Subject: RE: Pharos Quay, River Road, Littlehampton - LU/13/22/PL

The applicant is prepared to agree to remove the boxing in of the eaves, soffits, fascias, bargeboards etc. and the cladding above the doors/to the side of the bin stores and the cladding to the porch canopy roofs from the application in order to secure planning consent for the replacement white PVCu casement windows.

DRAWING CHANGE DETAILS:		Towns and Sperm and on added to window & door schedule, sash towns removed	
PROJECT:		Pharo's Planning Drawings, BN11 ZSP	
TITLE:		Window Elevations (Sheet 3 of 3)	
PROJECT NO.:		21-75-869W	
S.I.H.		E3	
CHECKED BY:		P.F.	
SALES PERSON:		Kean O'Neil

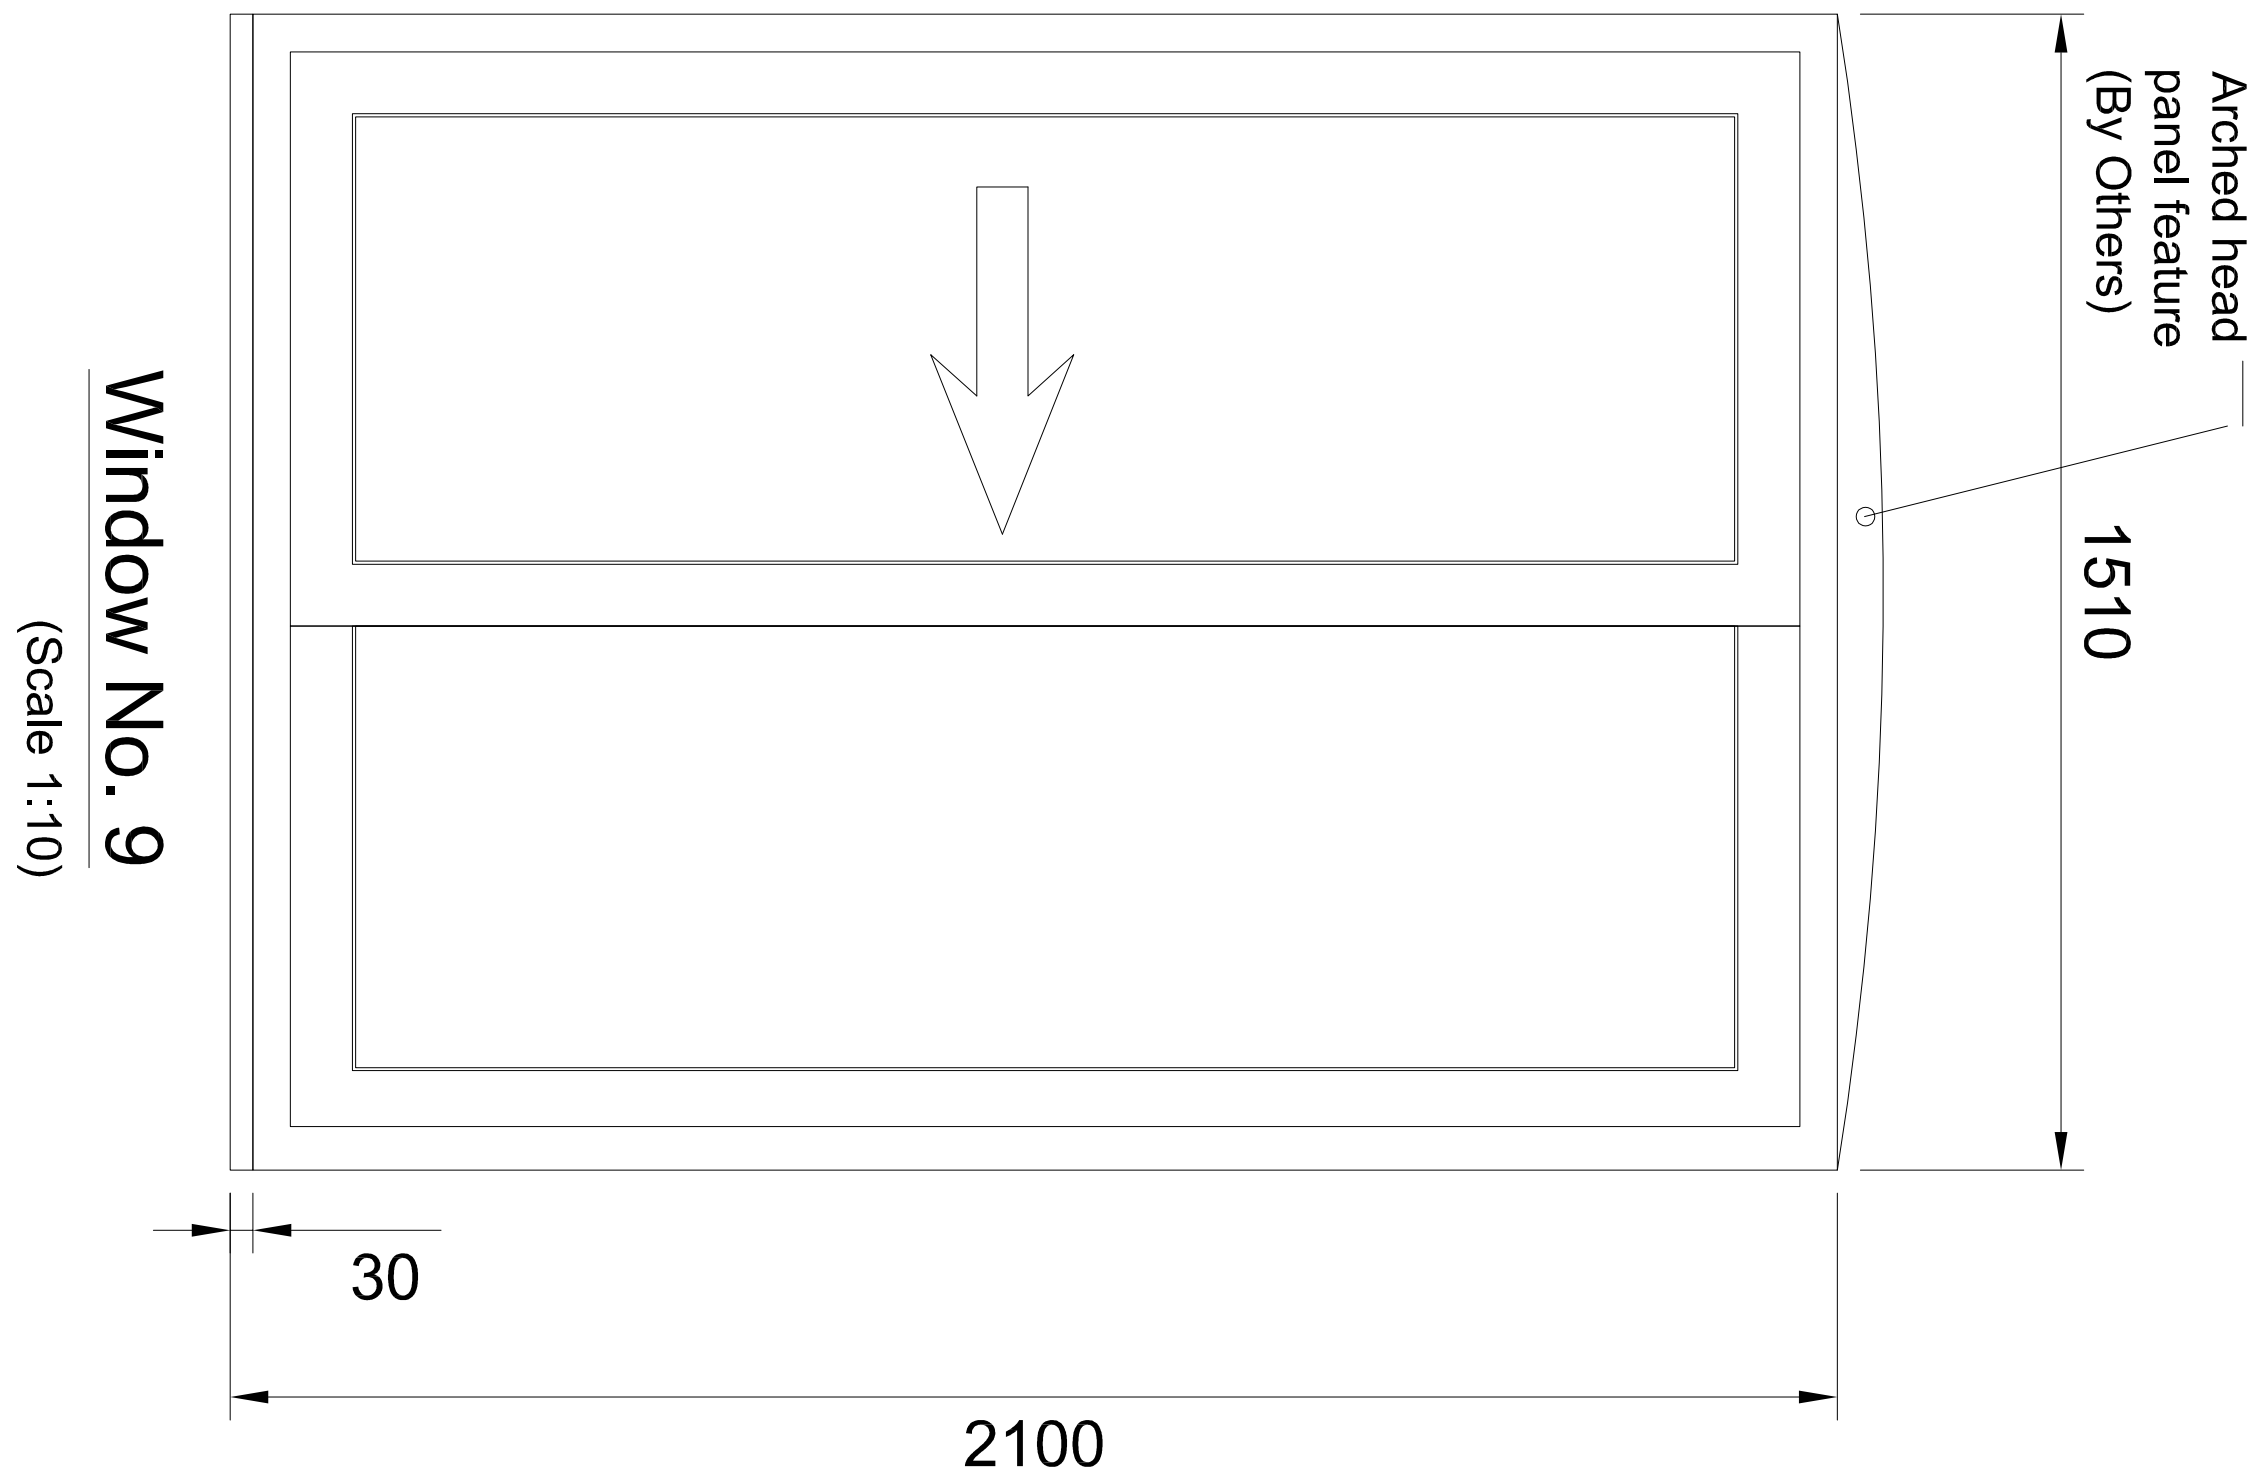
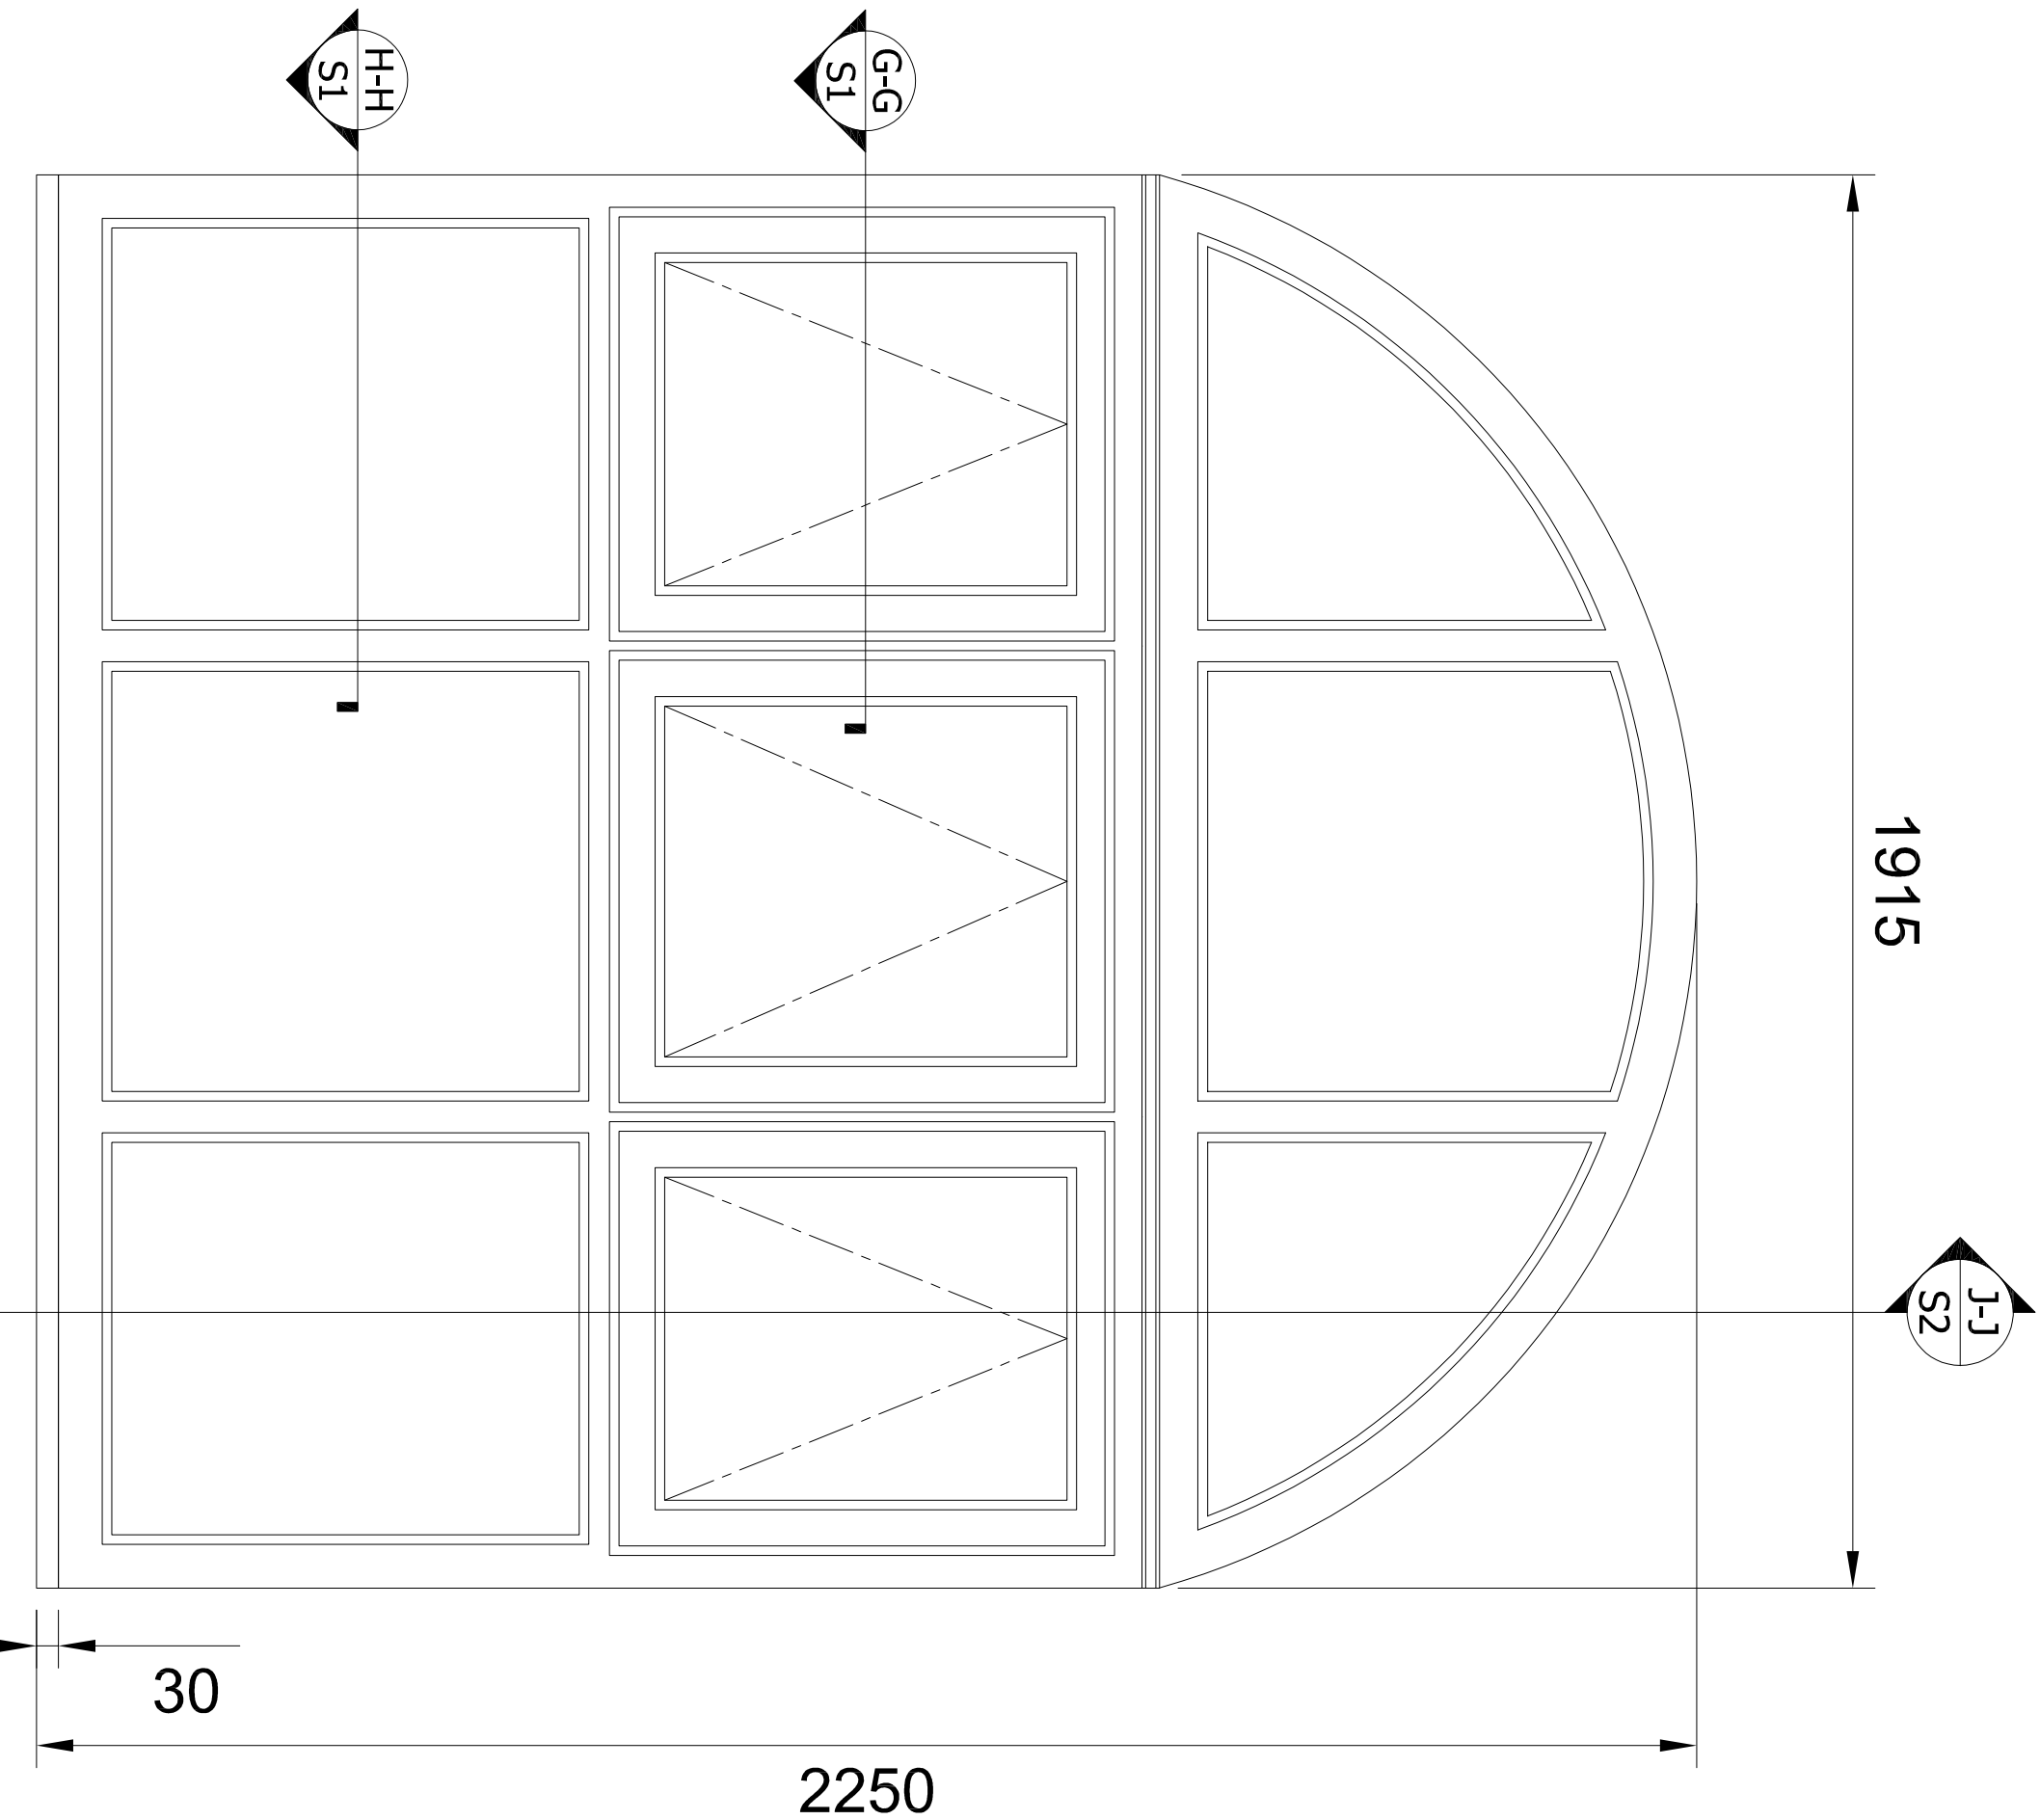
The details sent through for point 4 still look a little 'chunky' to me. As I said over the phone, in order to utilise Upvc windows in heritage locations we normally stipulate heritage glazing, where not only are the glazing profiles slimmer but the frames also. It has been very useful to see the side-by-side comparison, my biggest concern is the upper opening part of the window and not the fixed pane at the bottom, it is significantly larger than the existing timber frame. Is this something that can be rectified? If this can't be done in time I happy to approve with a condition for further details.

1. PVCu replacement windows, in principle, would receive your support. Not high gloss finish but with timber woodgrain effect as specified.
2. You are supportive, in principle, of casements and do not see the need for varying the style to vertical sliding sash windows.
